Ribble Valley Borough Council
Church Walk,
Clitheroe,
BB7 2RA

Phone: 0300 123 6780
Email: lhscustomerservice@lancashire.gov.uk
Your ref:
Our ref: LHS/CS/3/2016/0342
Date: 12th May 2016

Proposal:	Discharge of condition(s) 3 (external materials), 4 (boundary treatments/bins), 5 (construction method statement) and 7 (desk study of planning permission 3/2015/0183).
Location:	Land at no.78 Riverside Low Moor Clitheroe BB7 2NS
Grid Ref:	372978 - 441995

The Highway Development Control Section has made the following comments regarding the discharge of conditions 5 (construction method statement): -

Proposed Site Plan  
1:100 Scale

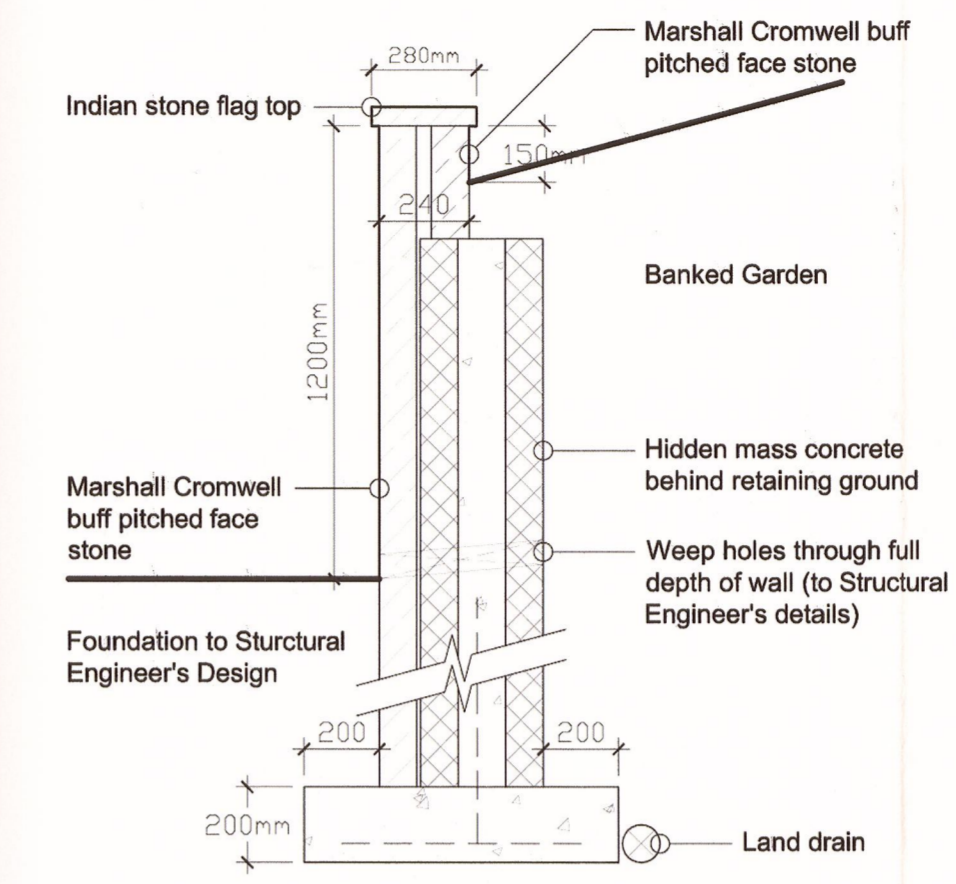
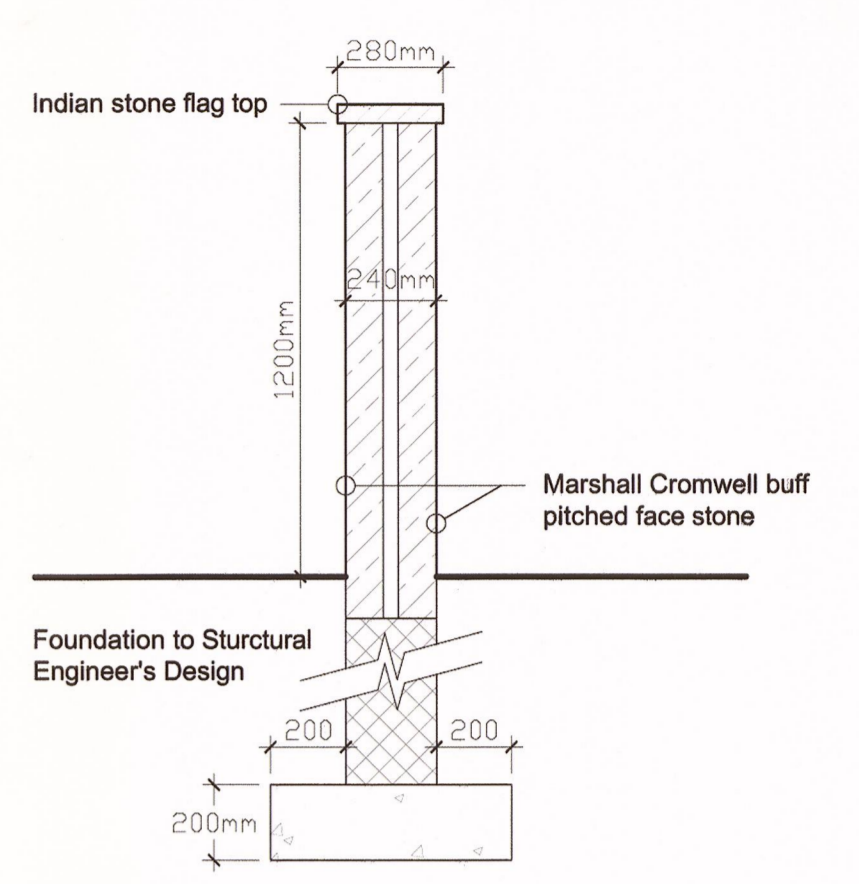
To aid with the operatives parking, deliveries and storage of materials the Highway Development Control Section recommends the shown drive and parking bays are provided up to at least the capping layer. This hardstanding area would also reduce the likelihood of mud and materials on the adjacent highway.

Facilities for cleaning wheels have not been provided or for arranging for road sweeping to be used as required.
